CONSTRUCTION DRAWINGS FOR REX ROAD AT FALCON REGIONAL PARK IMPROVEMENT PLANS

REX ROAD
 AT FALCON REGIONAL PARK
 STREET AND UTILITY PLANS
 COVER SHEET

REX ROAD
 AT FALCON REGIONAL PARK
 STREET AND UTILITY PLANS
 INDEX AND DETAILS SHEET

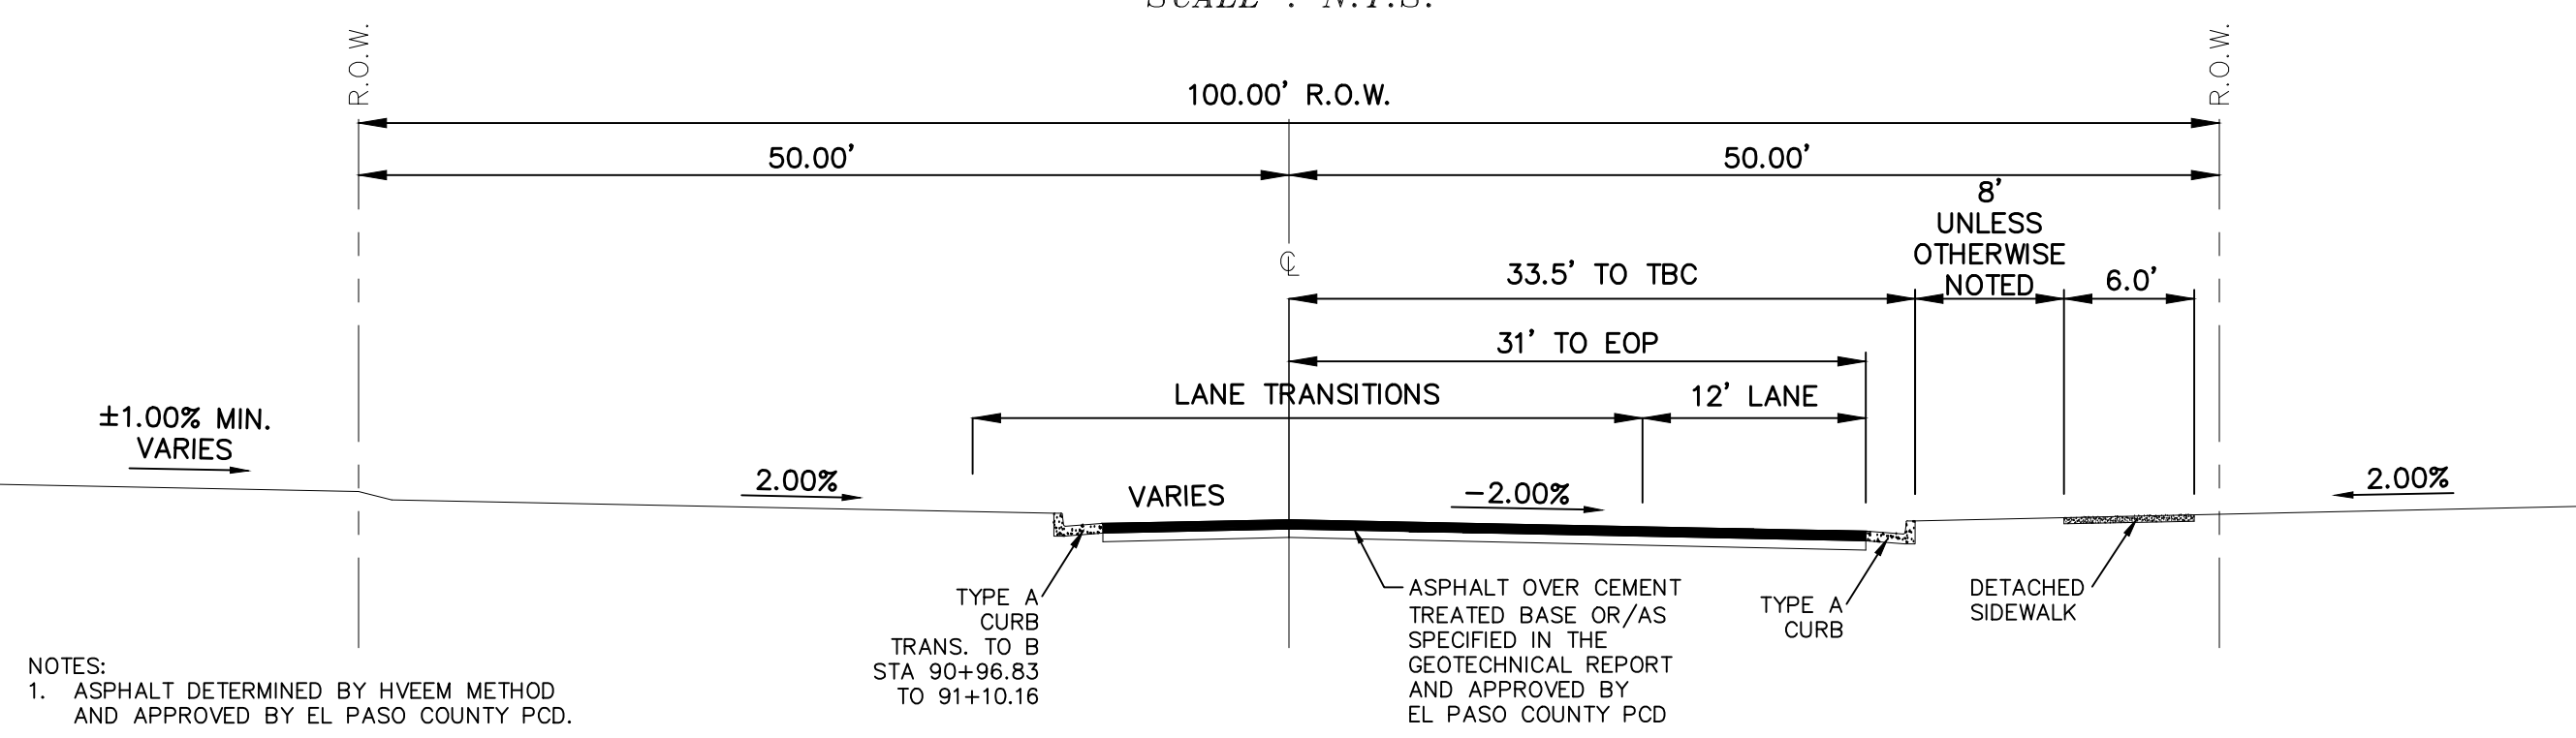
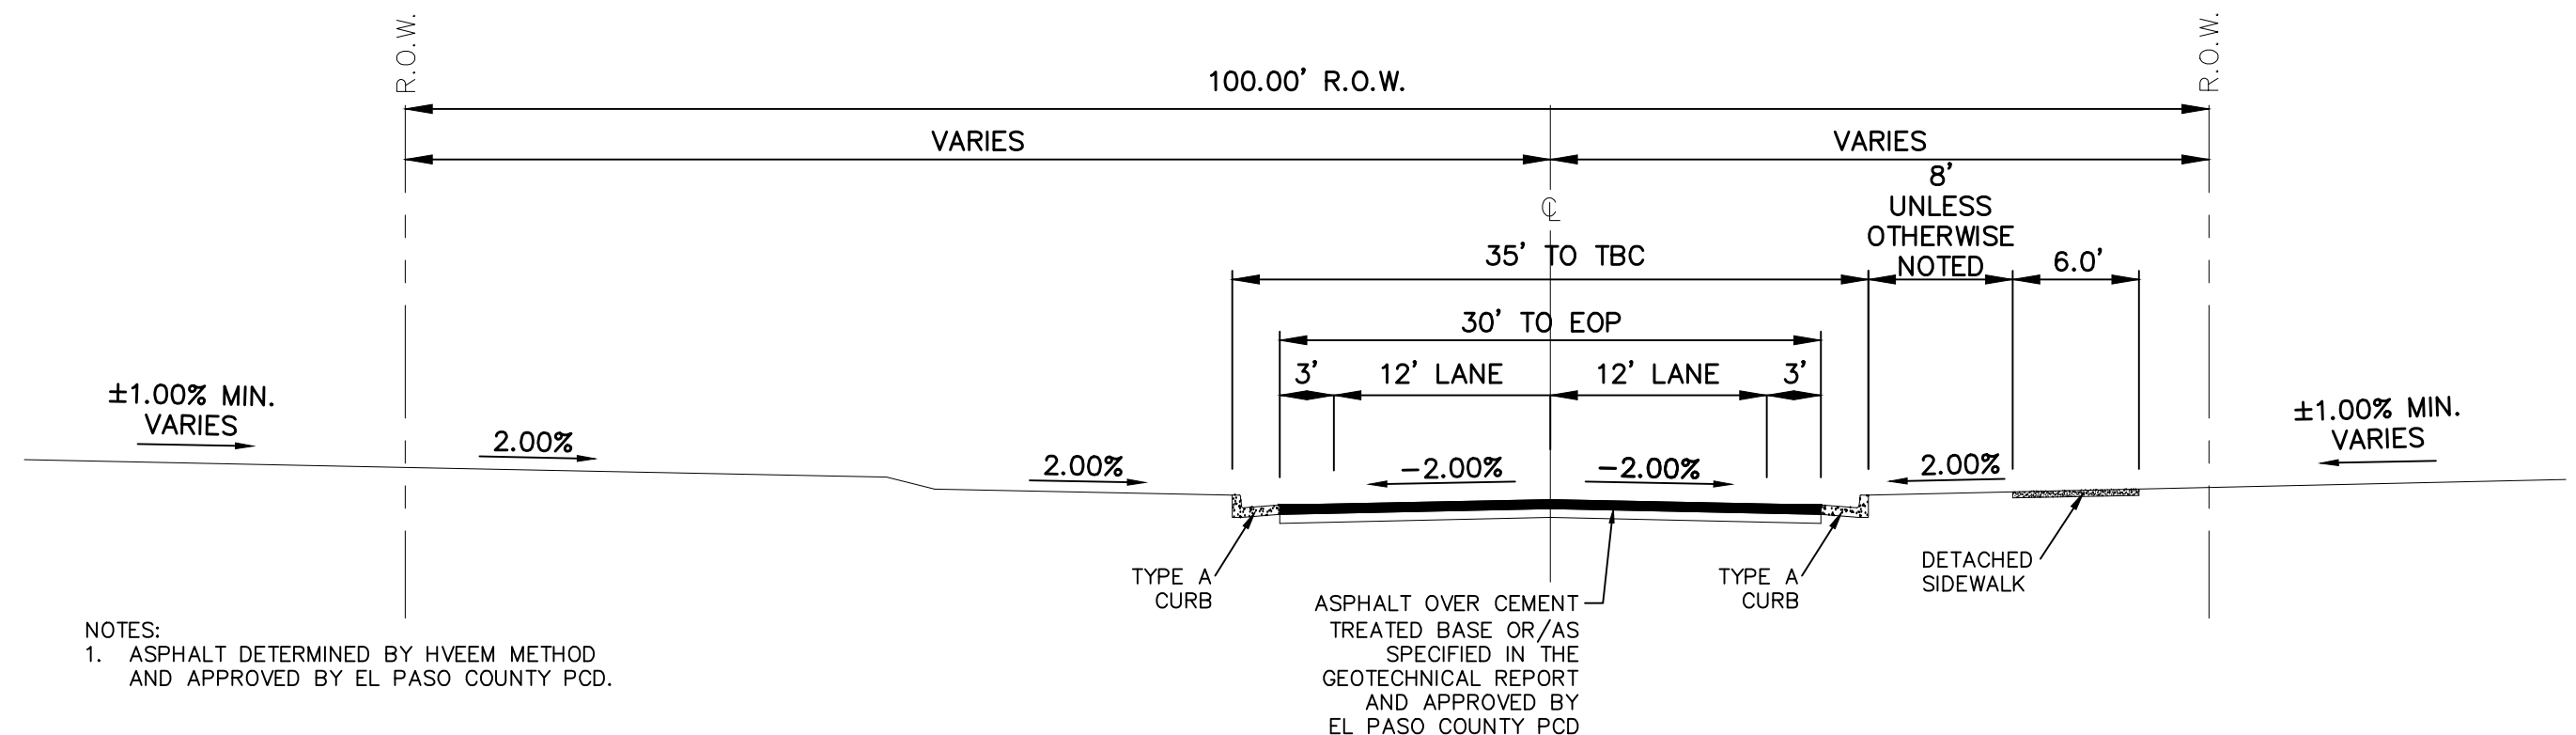
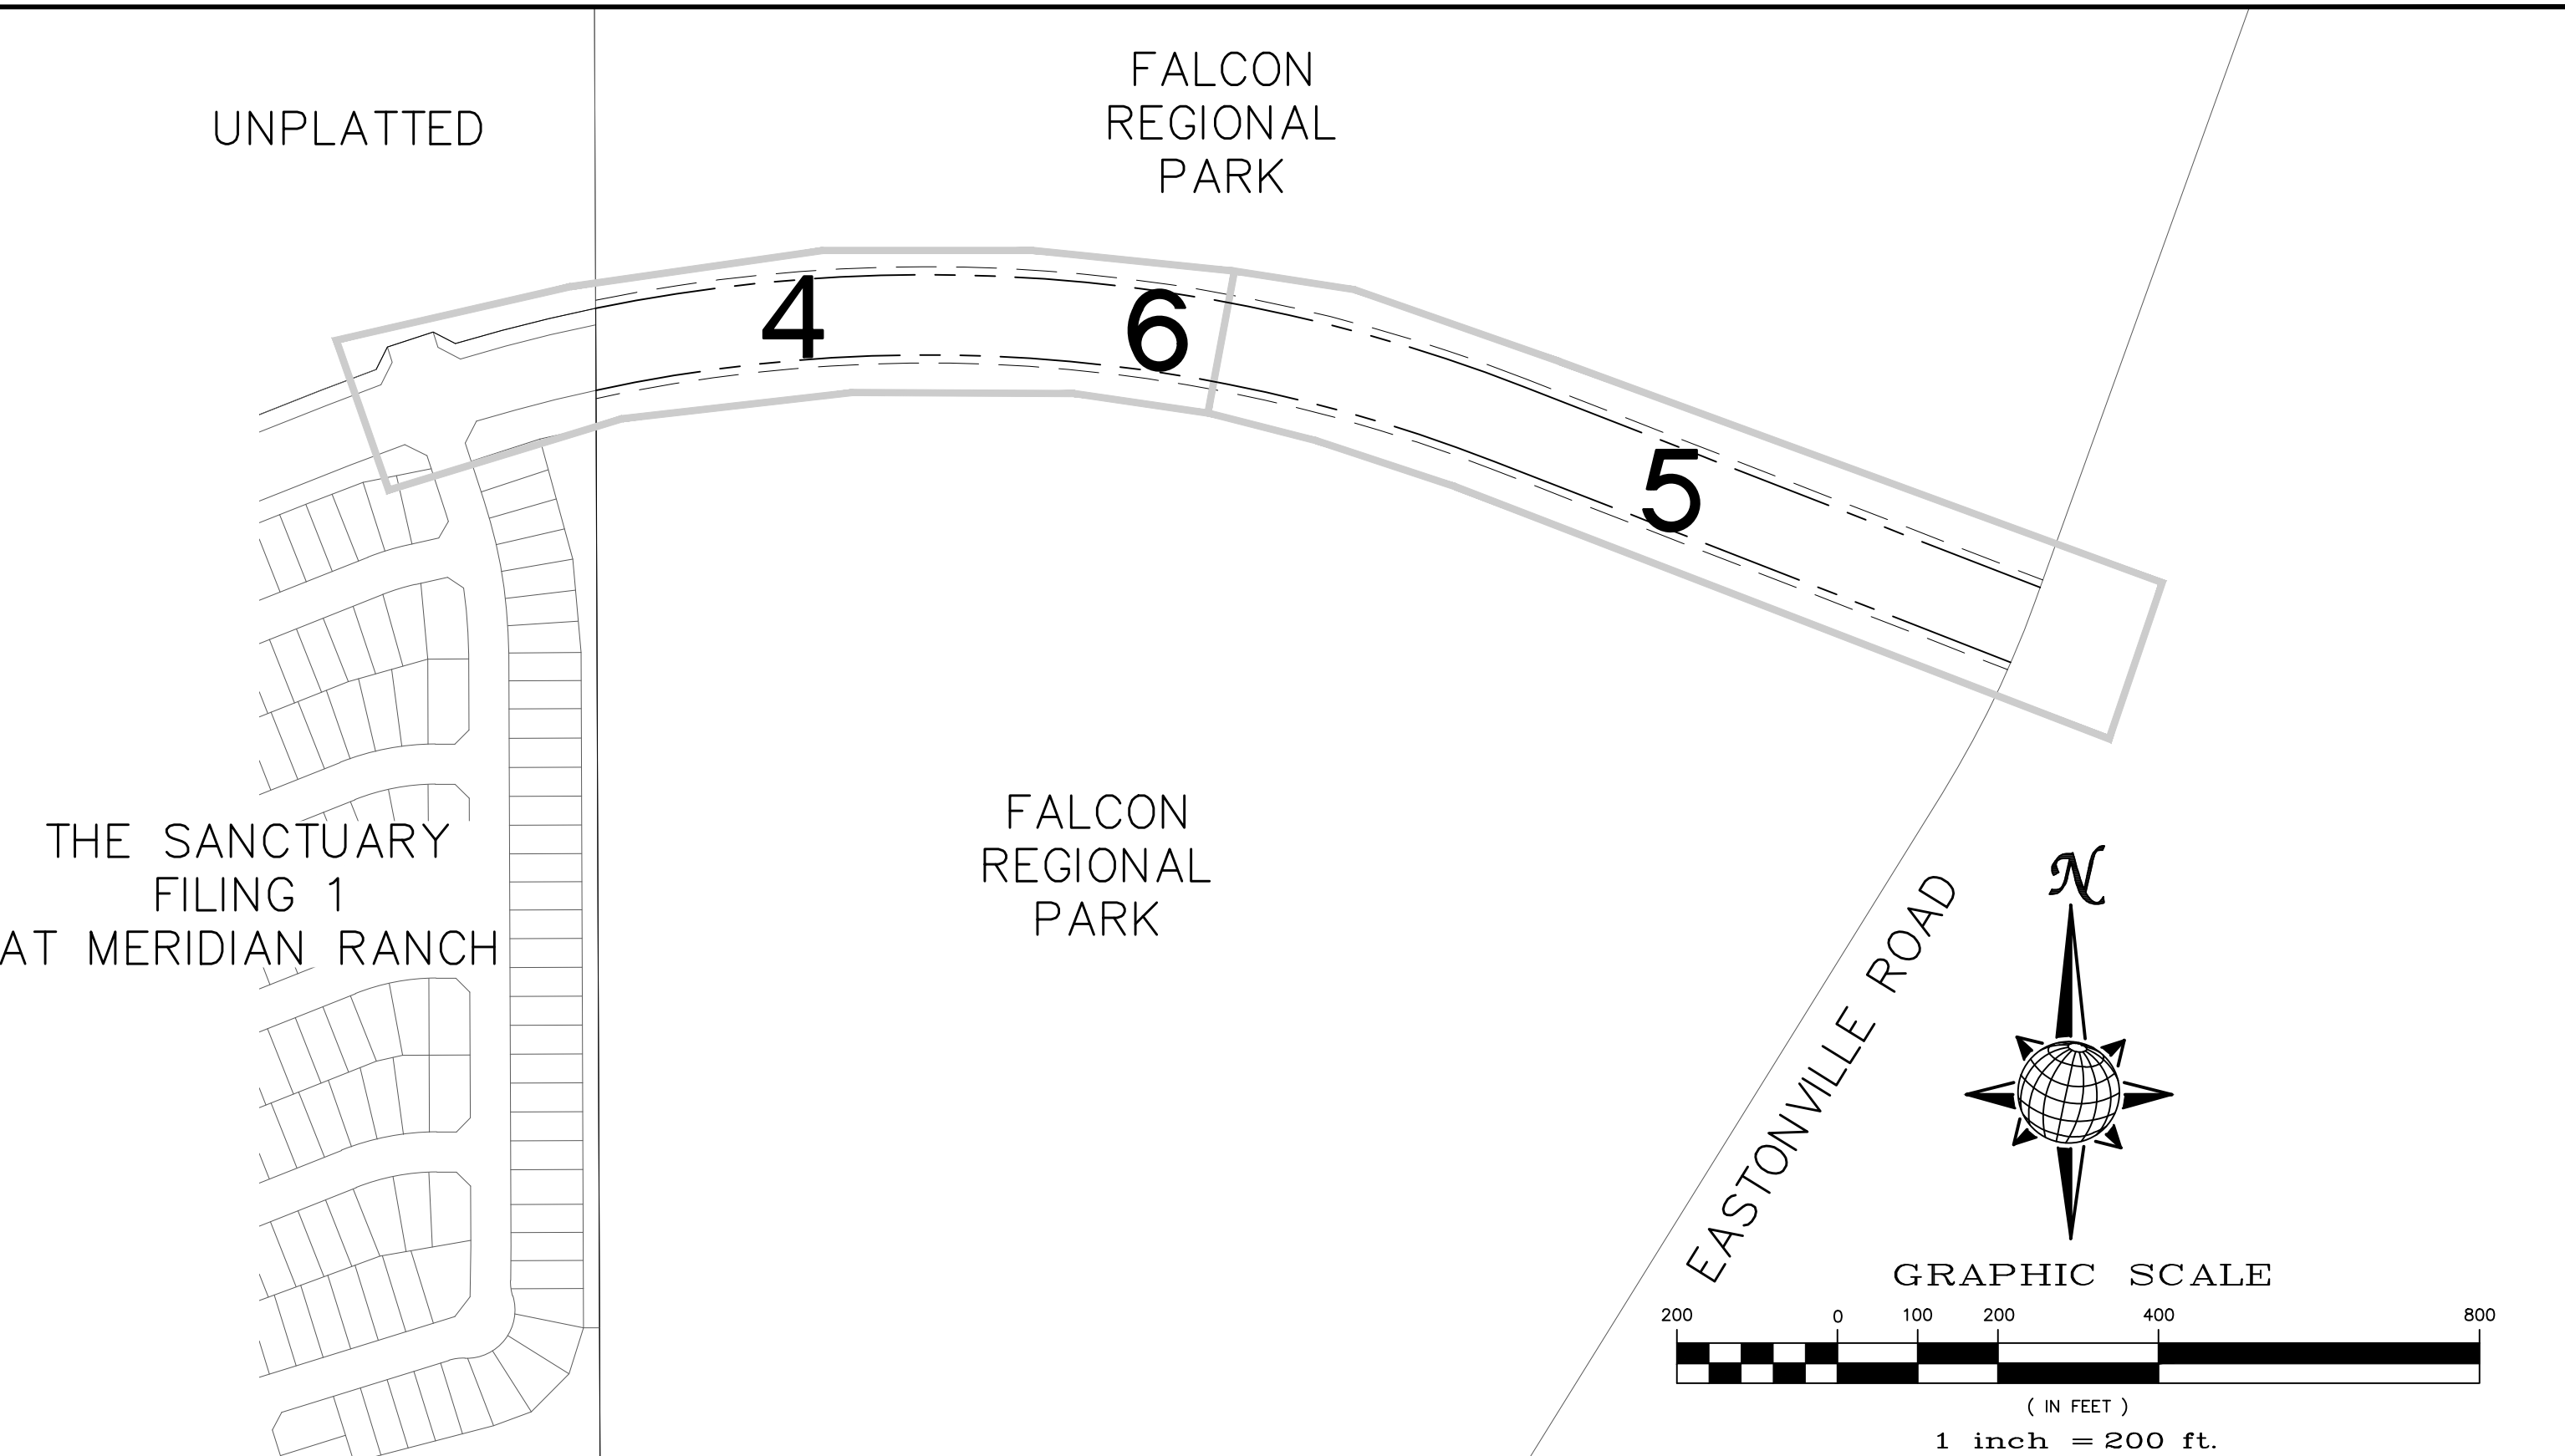
Did you mean cement treated base or are you proposing recycled concrete within the base course?
